Project Name: HURLEY REPLAT W/ A PORTION OF VACATED HARWOOD LATERAL

**CITY OF ALBUQUERQUE
PLANNING DEPARTMENT
January 23, 2008
DRB Comments**

RE: Lot 1, Hurley Replat w/ Vacated Harwood Lateral

**PLAT OF
 LOTS 1-A, 1-B & 1-C
 HURLEY REPLAT
 PROJECTED SECTION 5, T. 10 N., R. 3 E., N.M.P.M.
 TOWN OF ALBUQUERQUE LAND GRANT
 CITY OF ALBUQUERQUE
 BERNALILLO COUNTY, NEW MEXICO
 DECEMBER 2007
 SHEET 2 OF 2**

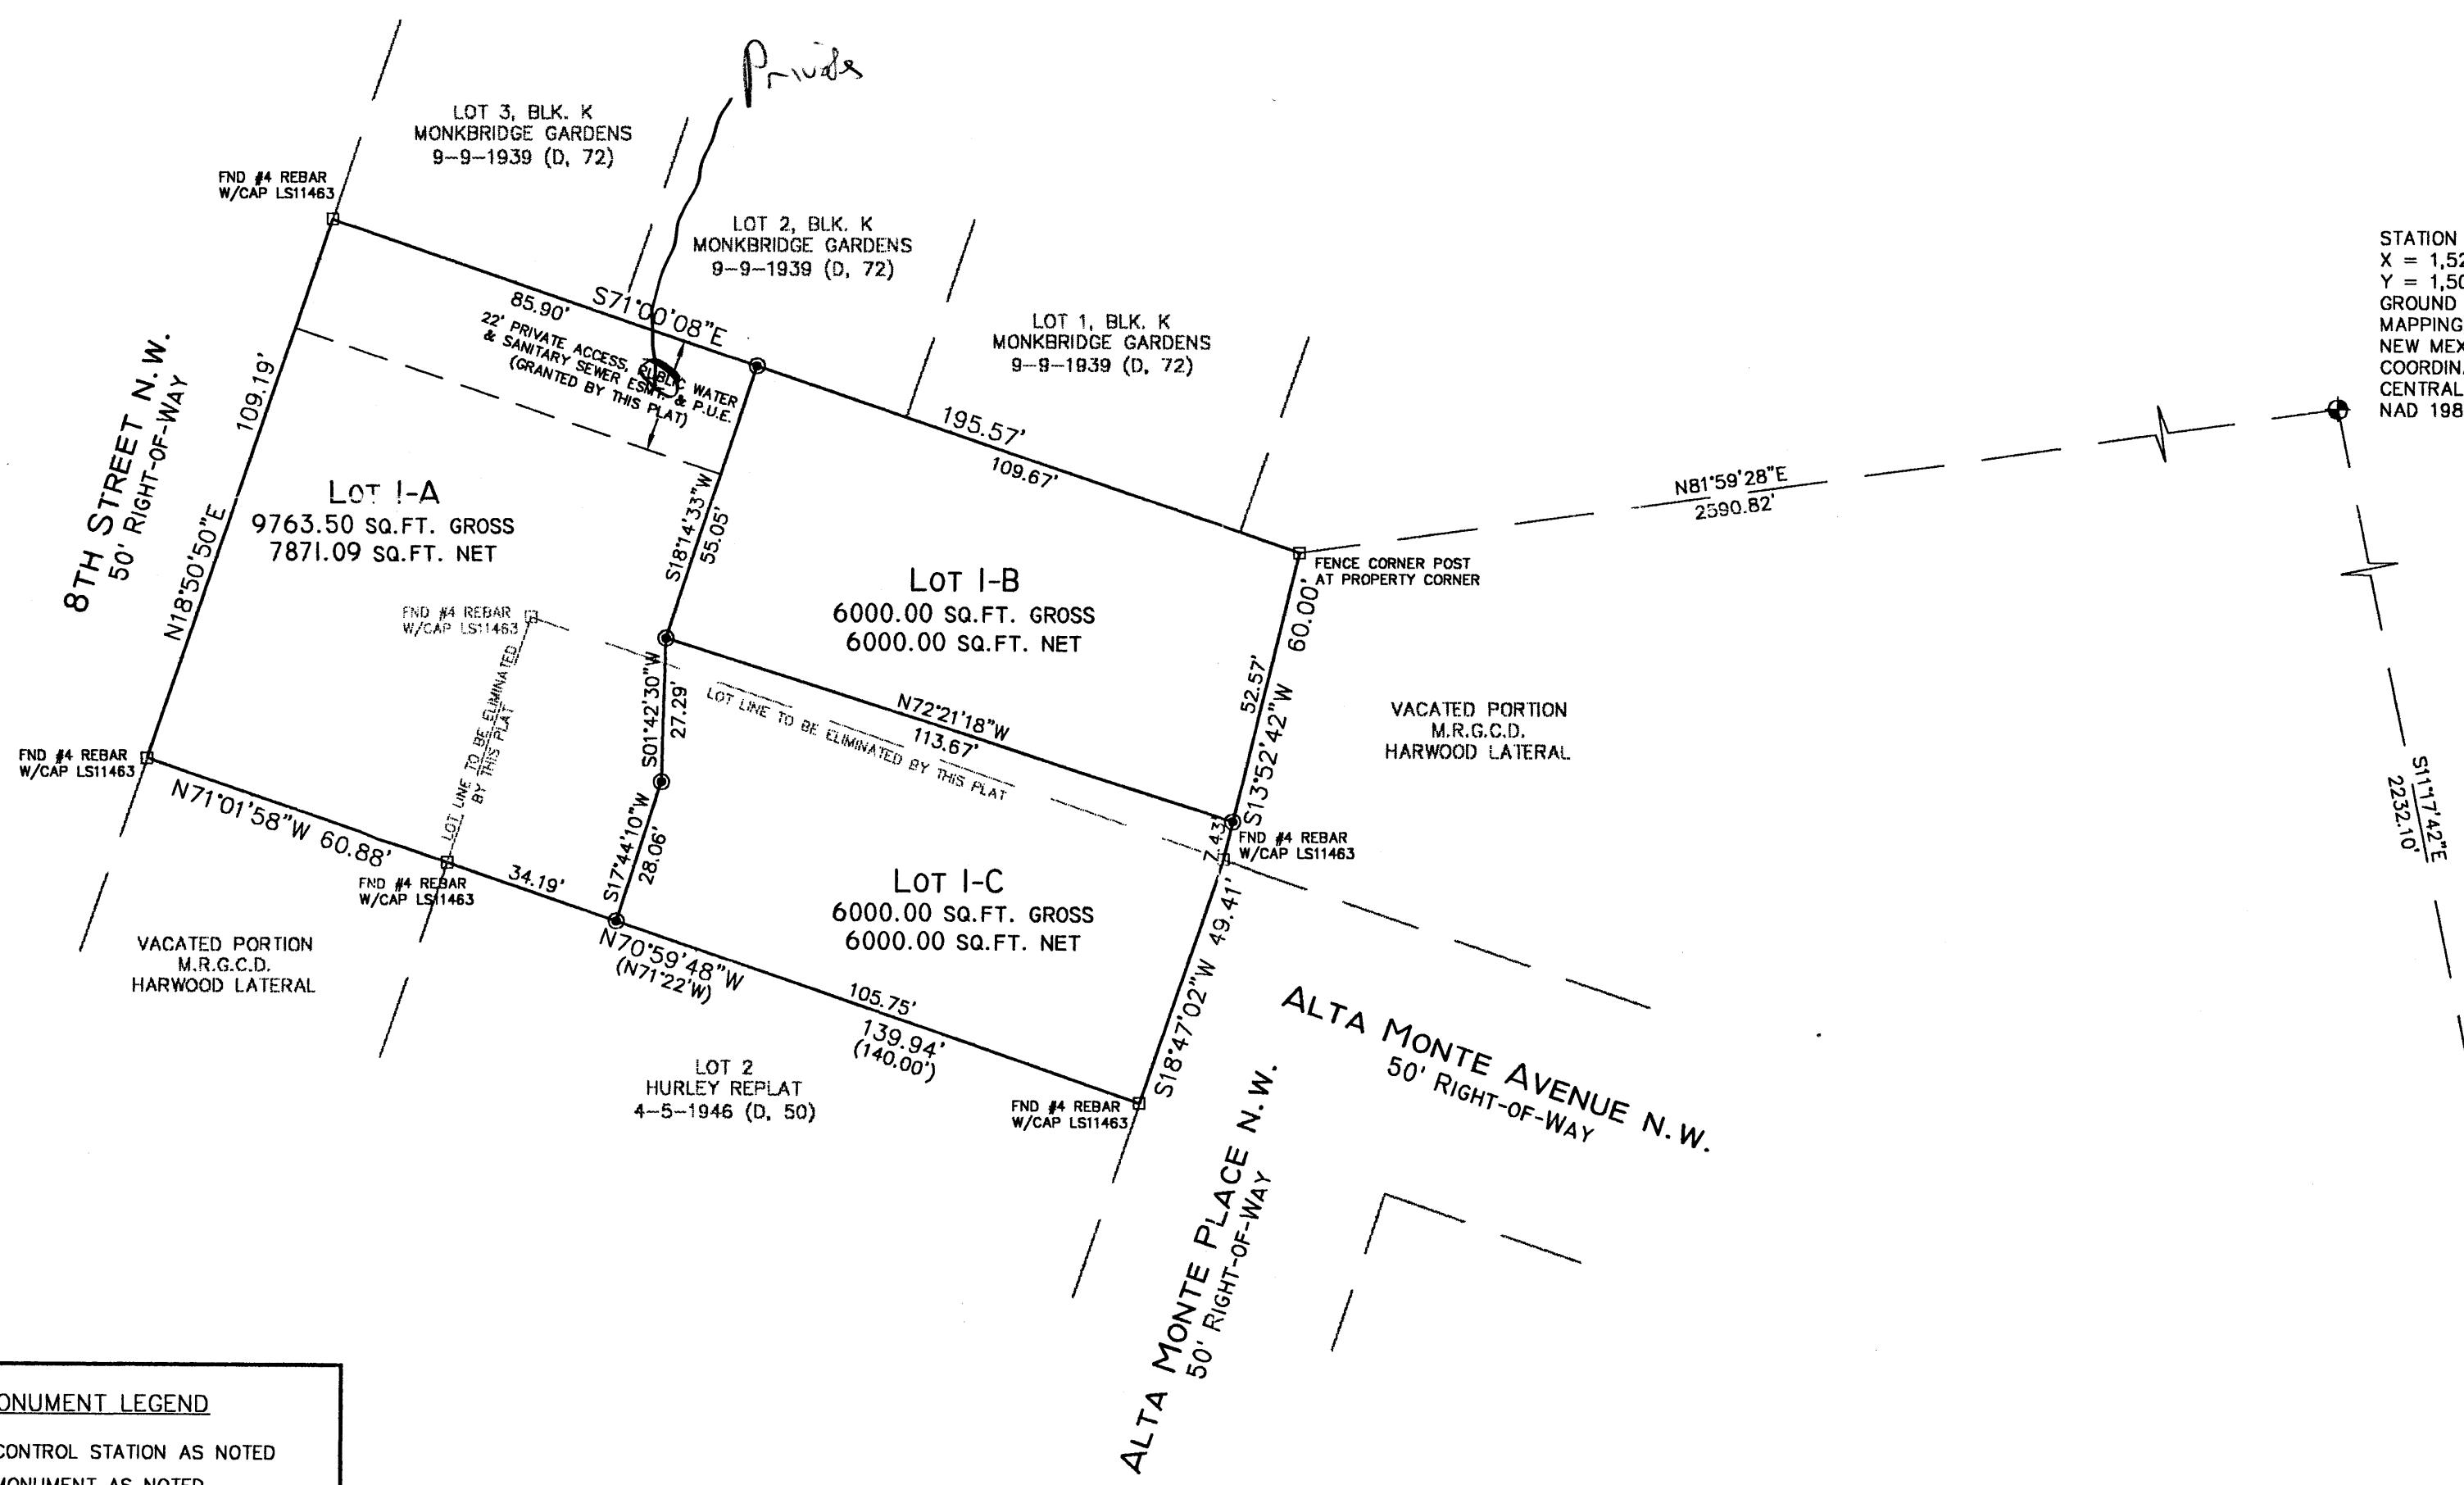
A minimum 10 foot setback is required on north side of existing house unless a waiver is signed, recorded, and submitted to the Planning Dept , in which case the setback would need to be a minimum of 5 ft [§ 14-16-2-6(E)(4) R-1 RESIDENTIAL ZONE –Sideyard Setbacks]

Accessory structures cannot stand alone on an R-1 lot (without a residence) – the structures on proposed Lot 1-A must be removed, or an application for a single family house building permit must be submitted prior to filing of the plat.
